# **Morecambe Offshore Windfarm: Generation Assets**

## **The Applicant's Response to Secretary of State Letter and Request for Information (Consultation 3)**

Document Reference: 10.2

ARCGIS REF: FLO_MOR_GIS_PRJ001_MOR_SoS_RFI_Rev001
DRAWING: FLO-MOR-GIS-MAP001-Figure 1-Rev002

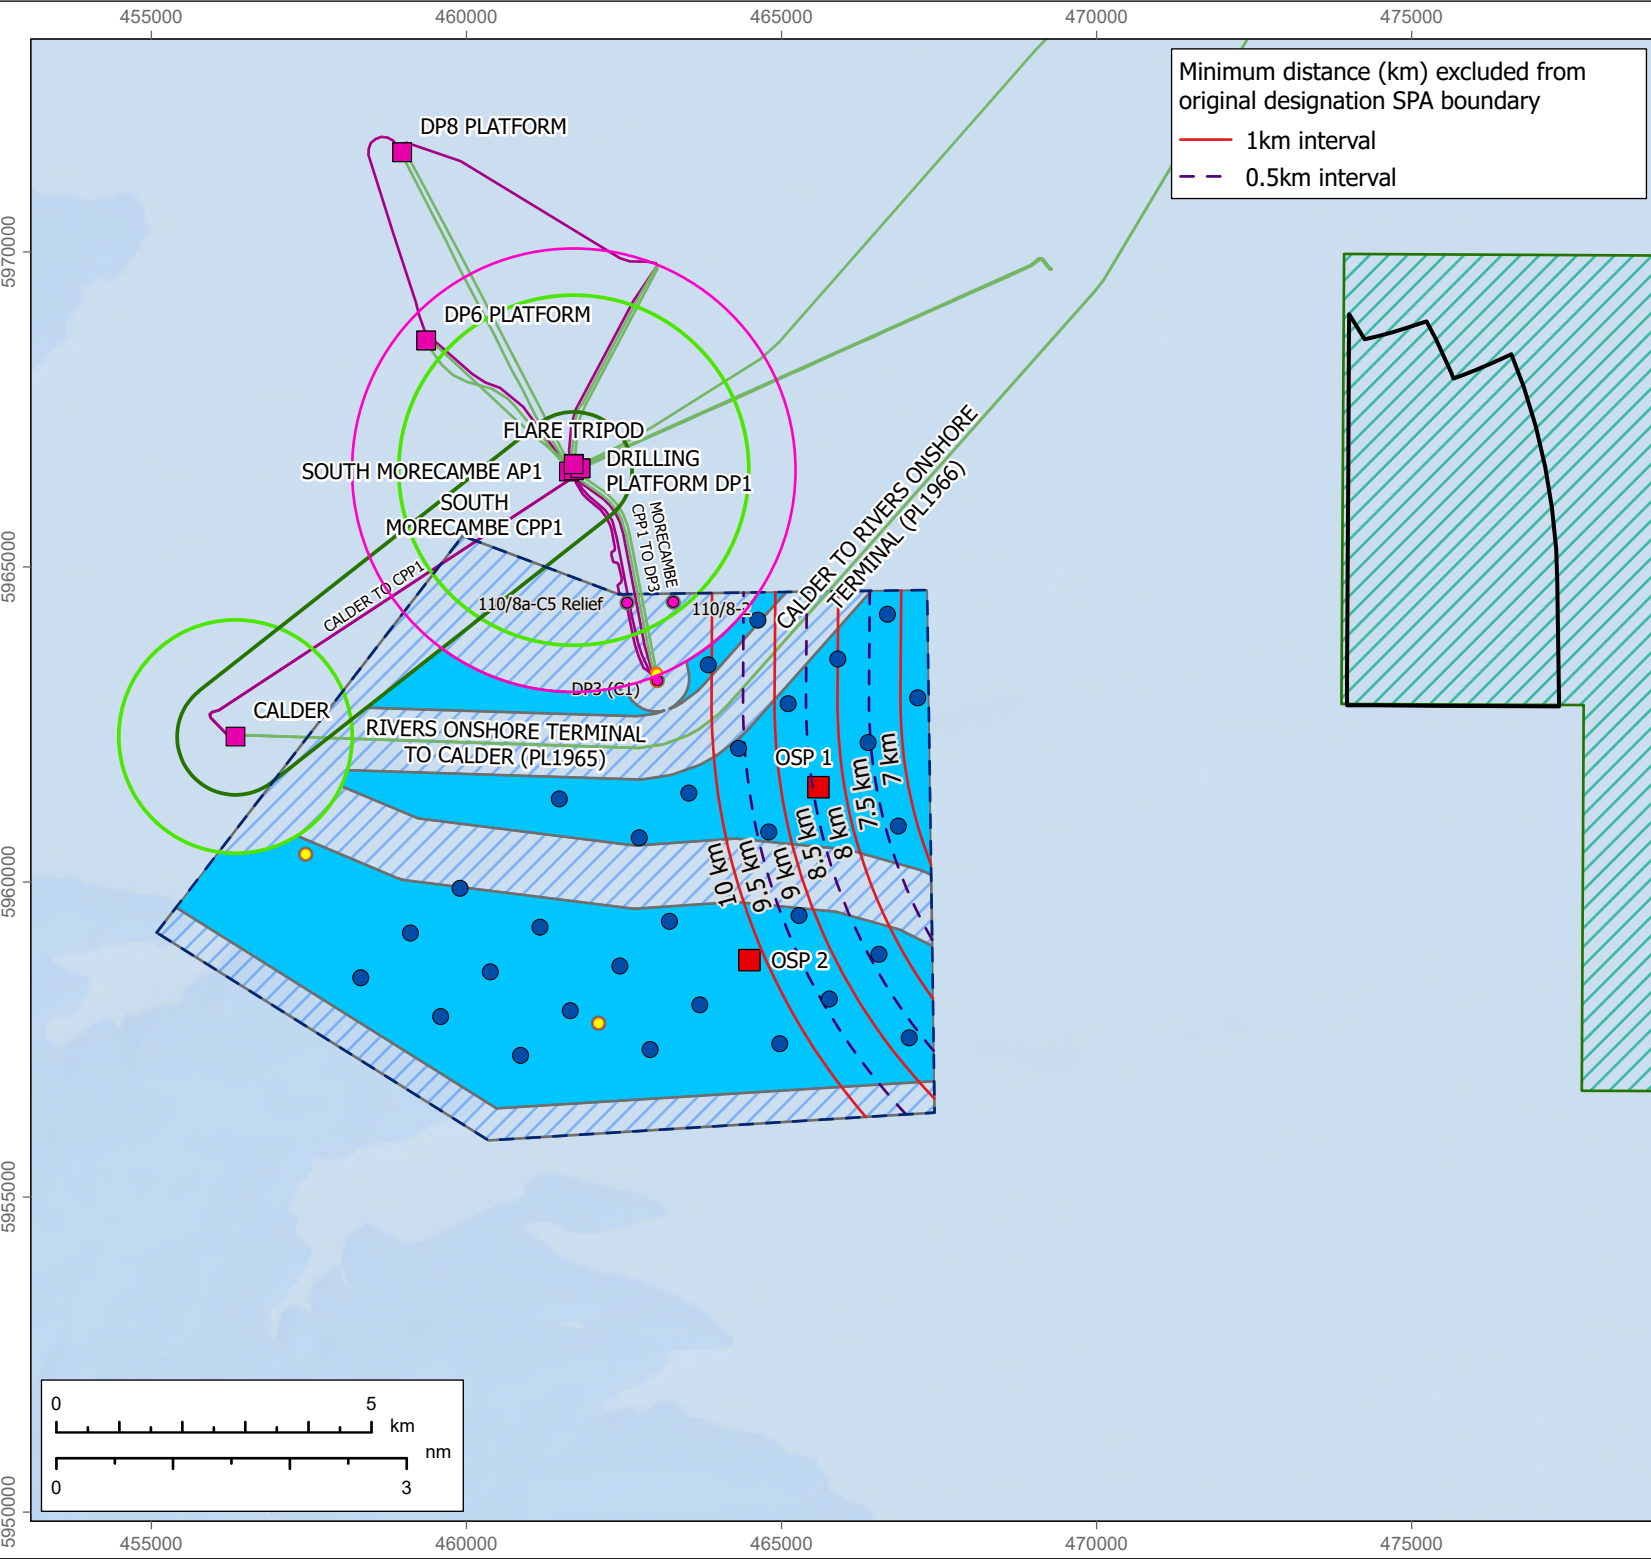
- The WTG and OSP aviation buffer zone (1.5nm), and WTG and OSP aviation buffer (1.9nm) around the Calder platform have been removed to reflect the agreed protective provisions submitted jointly with Harbour Energy in response to the SoS first request for information (CS1-011).
- The WTG and OSP aviation buffer zone (1.5nm) around CPP1 has been removed, as the Applicant has aligned the aviation enduring buffer with the distance identified by Spirit Energy (1.9nm), and confirmed by Harbour Energy, as being required for full day-time VMC access in their submissions during the examination.
- The WTG aviation corridor has been removed. Neither the agreed protective provisions with Harbour Energy, nor the protective provisions submitted by Spirit Energy at Deadline 6, include the aviation corridor because neither of these stakeholders has requested that it be included in

the suite of protections they would be entitled to under their respective protective provisions. Although the Applicant still considers that there is a benefit, it is a further restriction on the development of the project and so should not be included if those it seeks to protect do not require it.

- The constrained and unconstrained areas have been amended to reflect these revised buffers.

Drawing number	Description of Updates
Figure 1	Changed as outlined above.
Figure 2	Changed as outlined above.
Figure 3	Changed as outlined above. Single WTG within 1.9nm of CPP1 removed.
Figure 4	Changed as outlined above.
Figure 5	Changed as outlined above.
Figure 6	Changed as outlined above. Single WTG within 1.9nm of CPP1 removed.

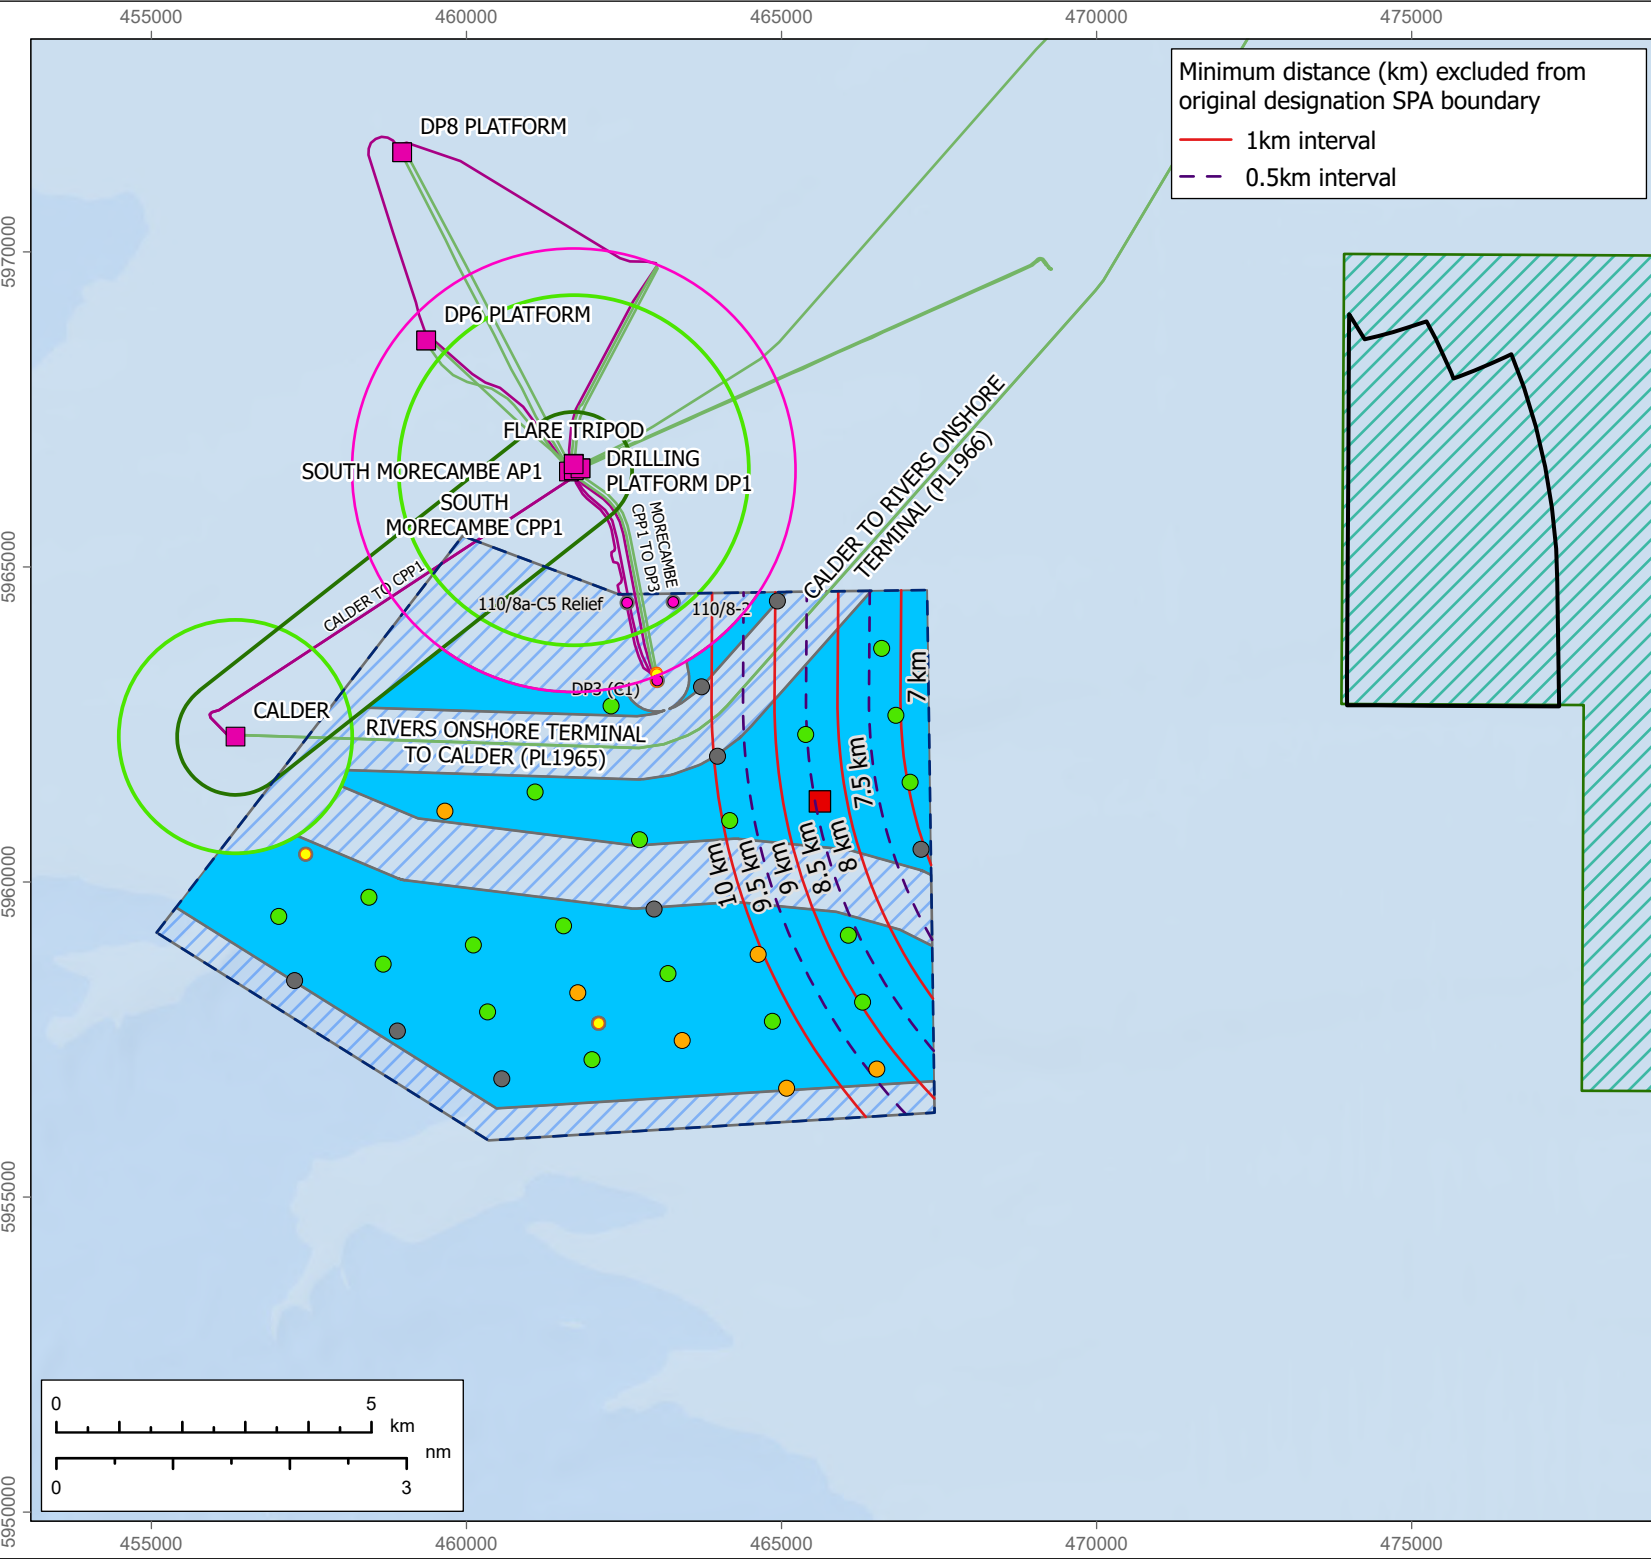
27. In response to the request regarding the relocation of WTGs to the south-western part of the site, the Applicant would direct attention to Figures 3 and 6 which show the current indicative layout. It is noted that this layout already made use of the area closer than 1.9nm to the Calder platform (up to 1.5nm) - so the Applicant had already made use of some of the potential to locate turbines in this part of the site. As noted in the question, the further reduction of the enduring buffer zone around the Calder platform from 1.5nm to 1nm was not taken into account in preparing this indicative layout.
